RE: **ABQ Ride Daytona Transit Facility**
Grading and Drainage Plan (Engineer's Stamp Date: 6/28/17)
Hydrology File: J09D025

Based on the information provided in your submittal received on 6/28/2017, the Grading and Pavement Plan Sheet C-7 with engineer's stamp dated 6/28/2017 and the Proposed Storm Drain Plan Sheet C-9 with engineer's stamp dated 6/14/2017 are approved for Building Permit.

<b>PARSONS BRINCKERHOFF</b>		CITY OF ALBUQUERQUE TRANSIT DEPARTMENT ABQ RIDE ABQ RIDE DAYTONA DESIGN	
PROPOSED STORM DRAIN PLAN			
DESIGN REVIEW COMMITTEE	CITY ENGINEER APPROVAL	MO./DAY/YR.	MO./DAY/YR.
City Project No. COA 5658.05	Zone Map No. J-09-Z	Sheet C-9

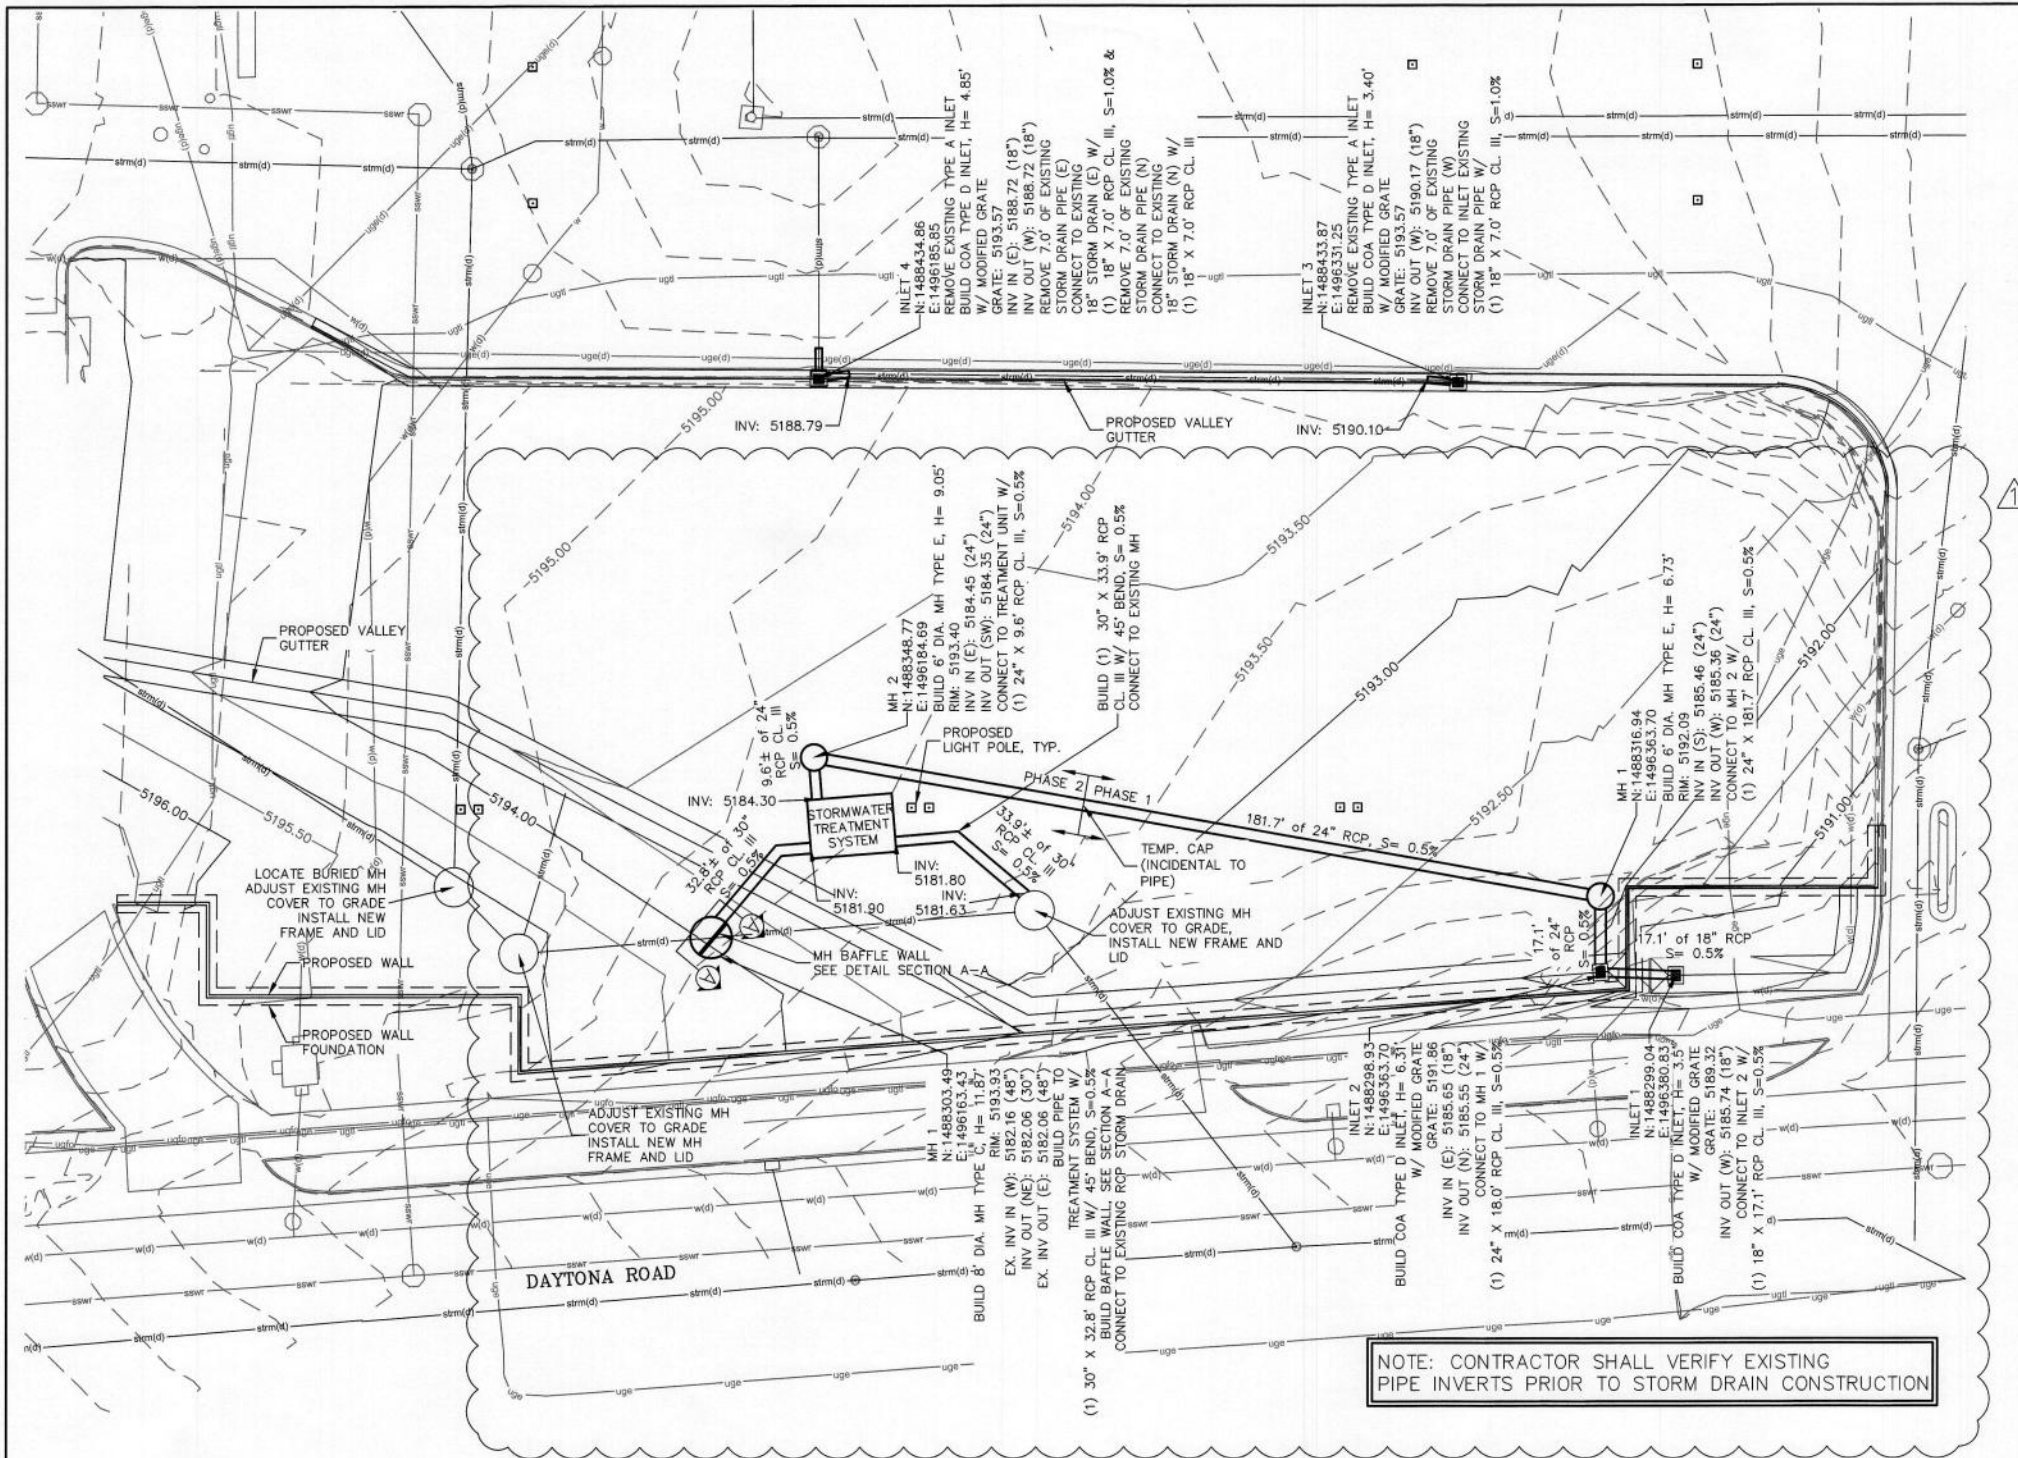
The following inconsistencies were noted during the review of the HGL calculations.

1. HEC-22 (2nd ed) was used which incorrectly applied losses directly to the HGL without calculating the EGL. The COA DPM 22.3.B requires the use of Bernoulli's equation and several other minor losses. If the HEC-22 (3rd Ed) option is used in the current version of StormCAD, the results will be consistent with the DPM. This will increase the HGL at the upstream end by about 3' so the HGL will be more than a foot out of the ground there.

2. Several things can be done to lower the HGL.
 - a. Starting with a lower tail-water elevation. The DPM allows use of the 10-year elevation of Pond 6 to account for the difference in timing of the peak stage in the pond and the peak flow in the pipe. That elevation is not known but it may be assumed to be at least 1' below the crest elevation of the emergency overflow spillway which is at 5182.6. So a reasonable starting elevation would be 5181.6.(1.4' lower)

- b. The peak flow rate in Daytona Street can be reduced to 195.86 cfs per Amole Hubble DMP (0.9' less HL)
 - c. The onsite peak flow rate can be reduced to 80 cfs since about 20% of basin U201 goes to a different storm drain.

When all of these changes are combined the resulting HGL will probably be below the surface, so the design will be in compliance with City Code 14-5-2-12(G).
